WRITTEN REPRESENTATION

HIGHWAY ENGLAND'S RESPONSE

M4 SMART MOTORWAY WORKS – MYRKE ALLOTMENT TENANTS

Drawing title
WORKS PLANS
REGULATION 4 (2) (e)
SHEET 23 OF 31
MYRKE

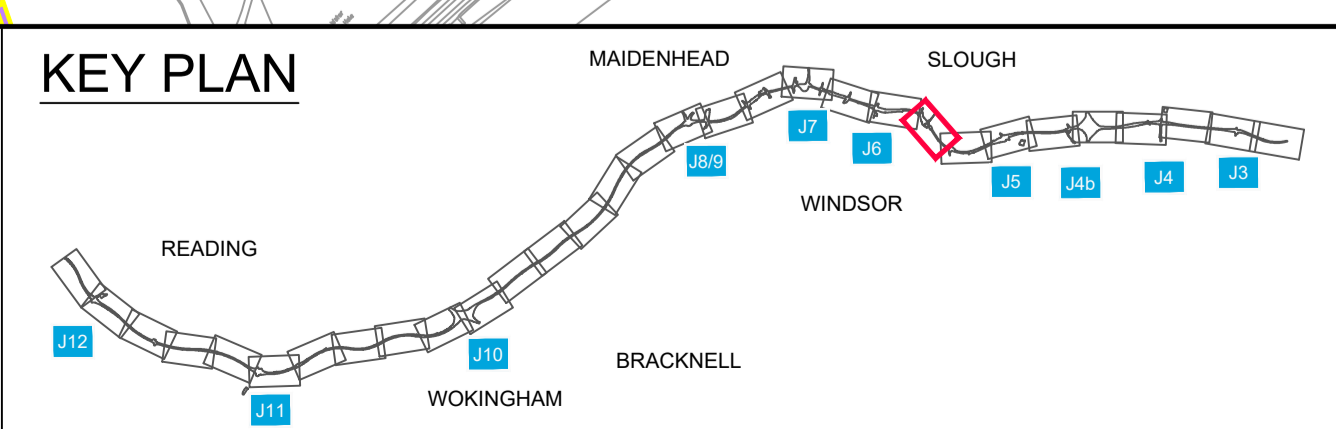
3.1 *The original plan indicated that a large section of the site (Plots 20 -33) would need to be temporarily acquired for Thames Water works to the main culvert. The Highways Agency (3rd June '15) said that they were looking at "alternative proposals to either reduce the extent of the works required or remove the need for the works entirely" and that a decision was expected mid-July '15. Given this, it was disappointing to have to wait until 25th September for an updated plan which does indicate a much smaller area will be acquired. (Revised plan attached, the redline indicates the original area identified for acquisition). This plan however has still not been formally agreed with Thames Water and does not confirm which plots will be acquired. The Highways Agency state (25th Sept '15) that "it appears to align with allotment plots 25 to 29 but I must stress that this should not be taken as definitive". Whilst we welcome this apparent reduction in the number of plots to be acquired the fact that it is not confirmed does extend the uncertainty of acquisition and put tenants of these and adjacent plots in a difficult position as to whether they should appeal or not.*

3.2 *Allotment tenants take great care in the management of their topsoil. Even temporary acquisition will destroy years of work. Due to the uncertainty, we have already seen a decline in cultivation standards of some plots in the area originally indicated. We need the Highways Agency to confirm which plots will be acquired as a matter of urgency to allow us to work with Slough Borough Council to minimise the impact on these tenants.*

3.3 *We also requested that The Highways Agency investigate if it necessary to take over the full length of plots (28m). The Highways Agency (9th Sept '15) confirmed the full length of the plot will be used. Looking at the current plan we do not see why this is necessary. Allowing tenants to keep part of their plot might allow them to move and store structures and topsoil. We would ask that this is given further consideration.*

3.2.1 Highways England has been engaging with Thames Water to determine the size of excavations, access arrangements and the working space required to undertake the works. This has led to a substantially reduced working area affecting fewer plots than first envisaged. Following a site survey on 28 October 2015, Highways England can confirm that only plot numbers 25, 26, 27, 28 and 29 will be affected by the works. Furthermore, Plots 25 and 29 which are located at the edges of the working area will only be partially affected during the works. A 3.5m wide strip of plot 25 and a 4m wide strip of plot 29 will remain available for use by the plot holders, as shown on Drawing TR010019-iii-01 in Appendix B to this response.

3.3.1 Thames Water has confirmed that the full length of each plot will be required, as shown on Drawing TR010019-iii-01 in Appendix B to this response, to undertake the works safely. This is in light of the space needed to accommodate plant, material and equipment storage areas, areas for pumping and disposal of ground water; access/egress for heavy plant/vehicles, turning of same vehicles and welfare facilities.
